RE: ATLANTIC & SANTA FE SUBDIVISION (BARELAS HOUSING)
(K-14/D92)
Engineers Certification for Release of Financial Guaranty
Engineers Stamp dated 10/29/2005
Engineers Certification dated 07/10/2006

Re: Barelas Housing, Block 2 Baca Addition
Grading and Drainage Plan
Engineer's Stamp dated 10-29-05 (K14-D92)

RE: Barelás Housing, K14-D92 Grading and Drainage Plan Engineer Stamp
Dated December 3, 2004

TITLE: GRADING AND DRAINAGE PLAN
ATLANTIC AND SANTA FE SUBDIVISION

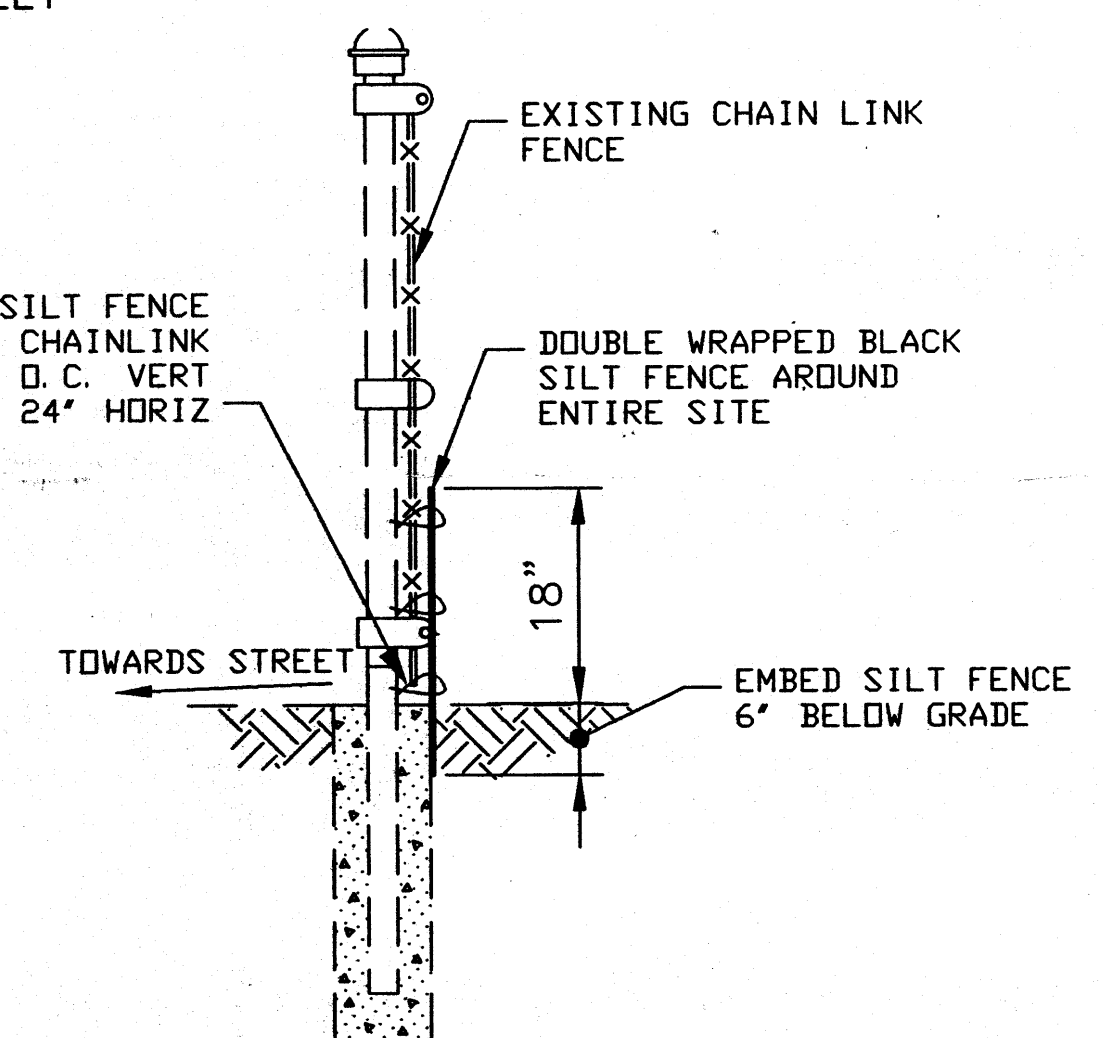
- 1- A grading plan that indicates spot elevations at all property corners, you will be required to certify this plan prior to the release of financial guarantees.
- 2- Clearly indicate the legal description on the grading plan on the top of page two at the upper left hand corner.
- 3- Indicate that the alley is going to be public.
- 4- Private drainage easements that are needed.
- 5- Lot numbers.

Spot Elevations @ all intersections

*Loop Street
Public
or
Private?*

Clear sight distance @ all intersections

- Albuquerque
New Mexico 87143
- 1- A grading plan that indicates spot elevations at all property corners, you will be required to certify this plan prior to the release of financial guarantees. — *Done*
- 2- Clearly indicate the legal description on the grading plan on the top of page two at the upper left hand corner. — *DONE*
- 3- Indicate that the alley is going to be public. — *DONE*
- 4- Private drainage easements that are needed. — *DONE ON PLAT*
- 5- Lot numbers. — *DONE*
